**Subject: DEVIATION REVIEW AND DECISION FORM**

**DEVIATION REVIEW  
 AND DECISION FORM**

Subdivision or Project Name: Winsome

Section of ECM from Which Deviation is Sought: Section 2.25.B.1 Spacing for Rural Minor Arterial

HODGEN RD  
IMPROVEMENTS

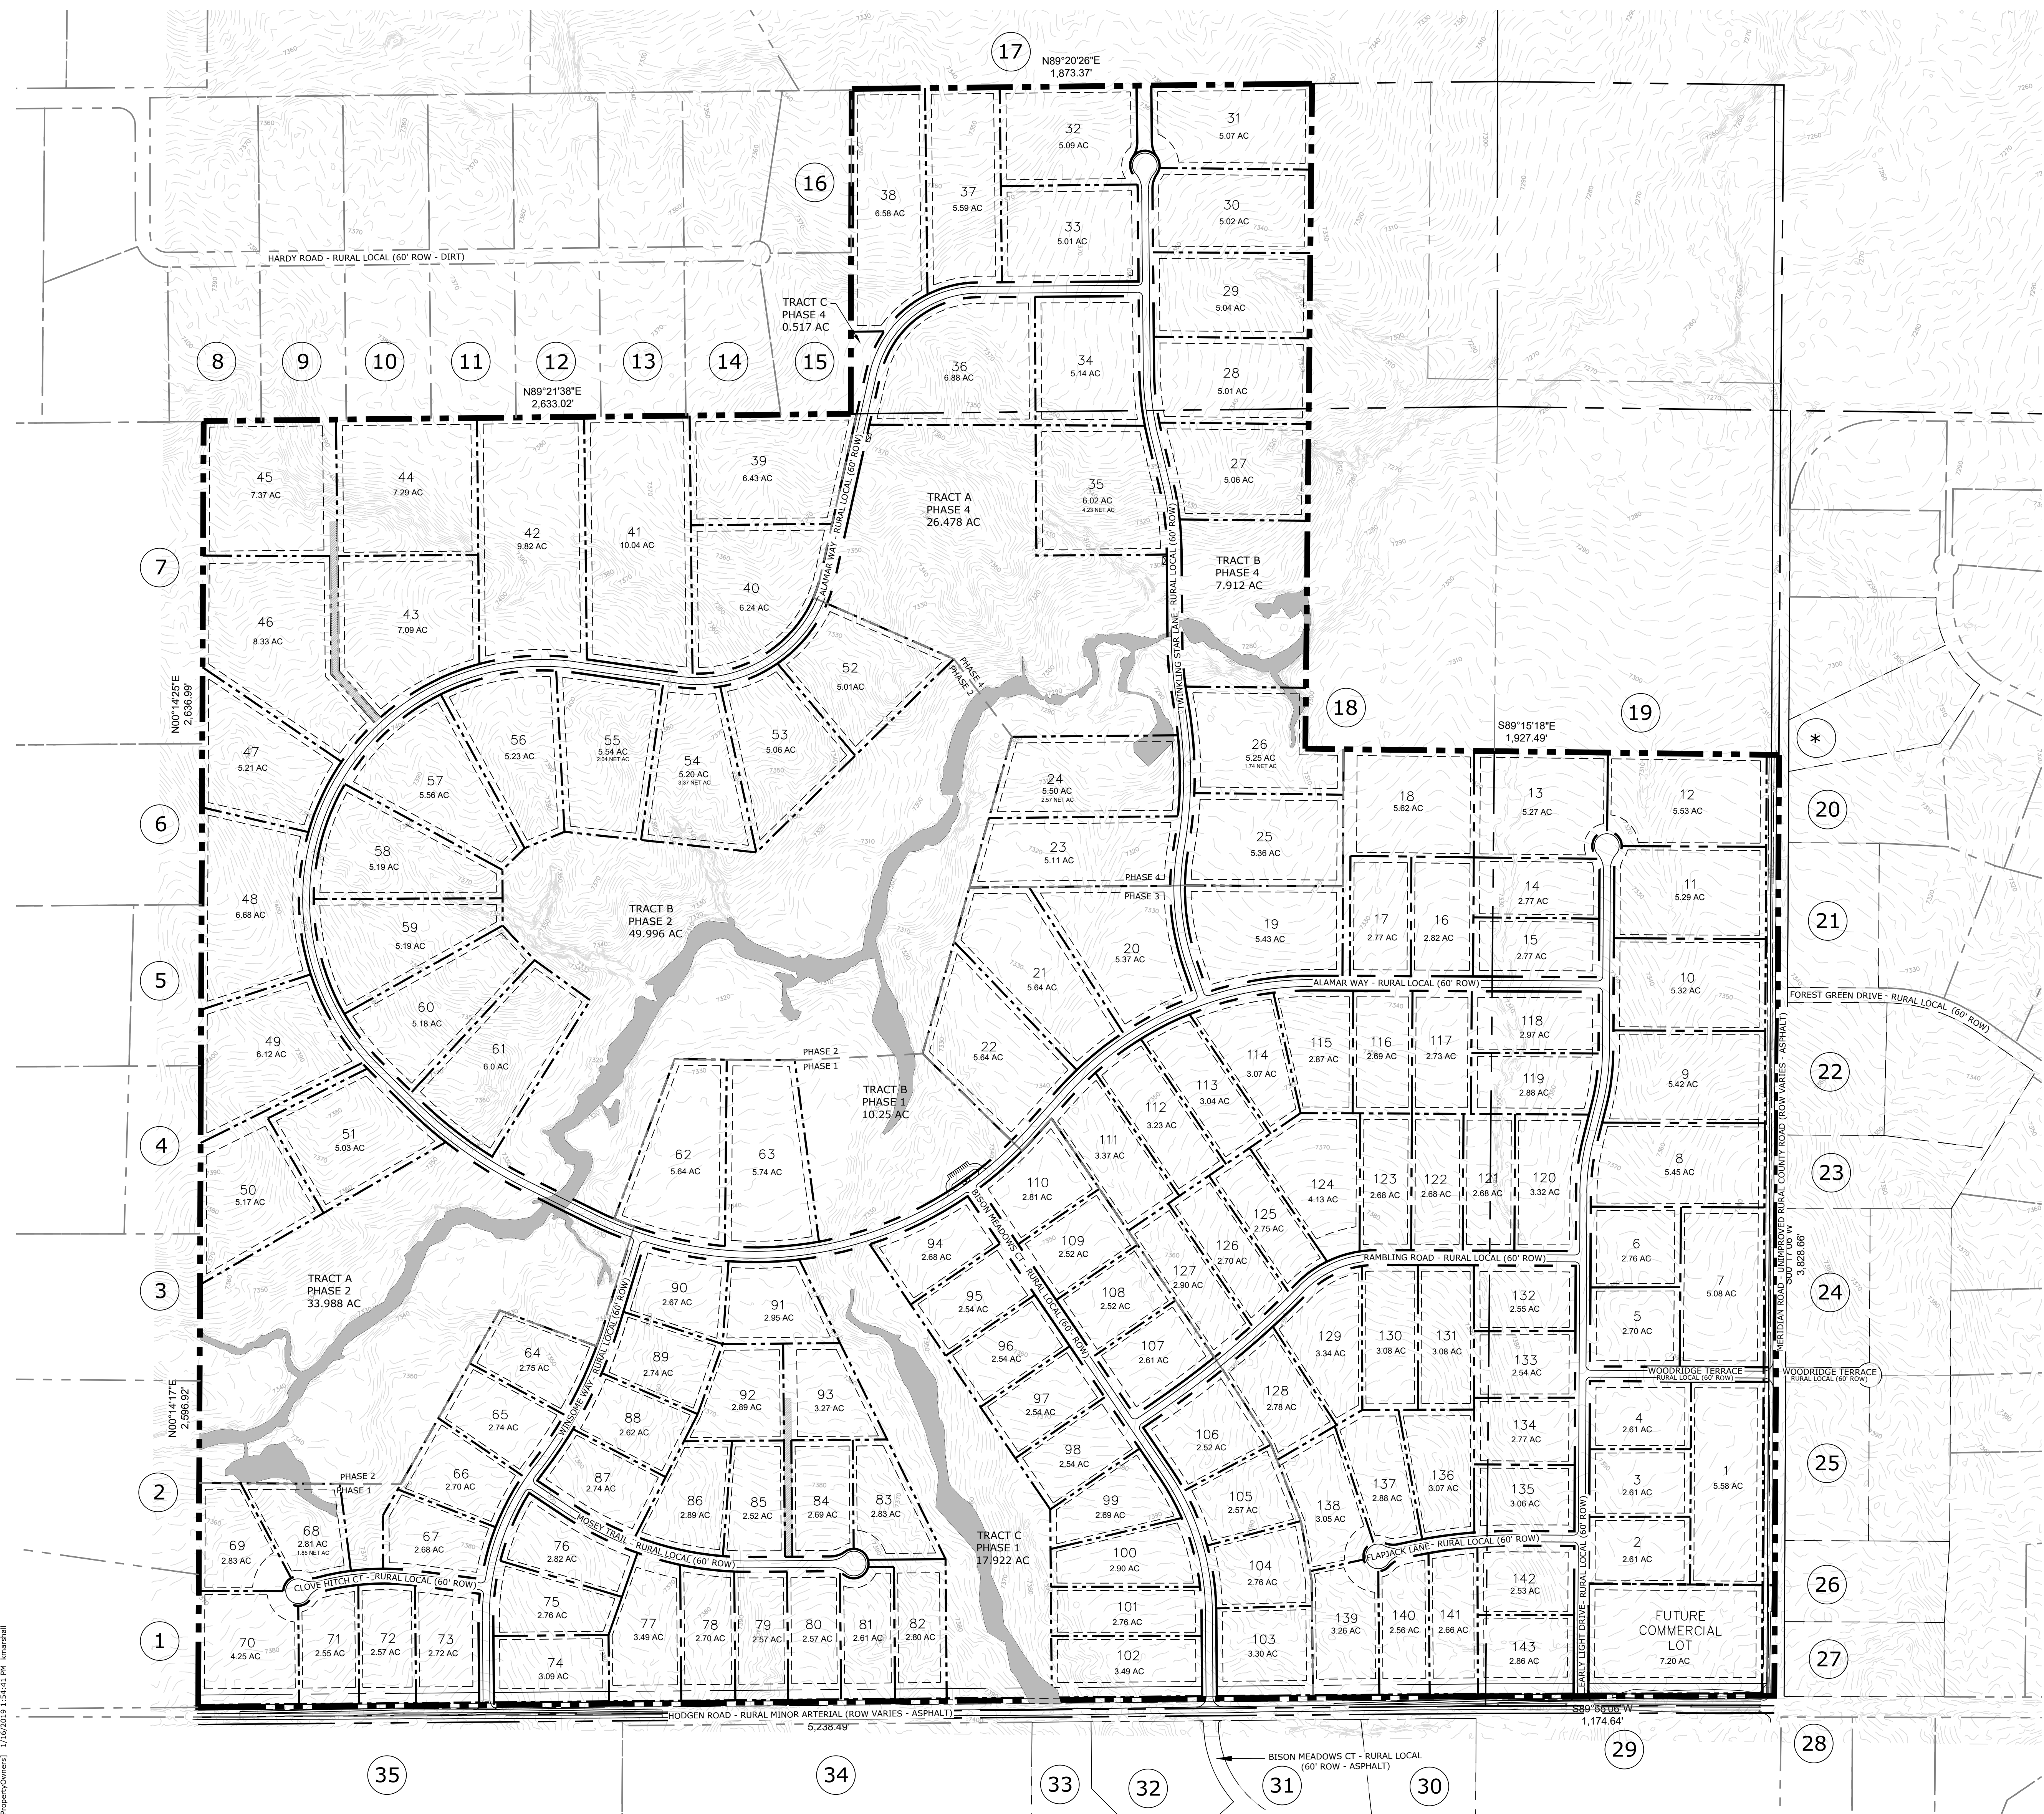
Elaborate on the justification/reason. There are two other access points on Hodgen plus one on Meridian Road. With a large undeveloped property there is sufficient room to reconfigure internal roads to provide access to the commercial lot without the 3rd intersection on Hodgen. Explain why the internal roadway can't be reconfigured so the third access (Early Light Drive) on Hodgen is not required.

While you've identified
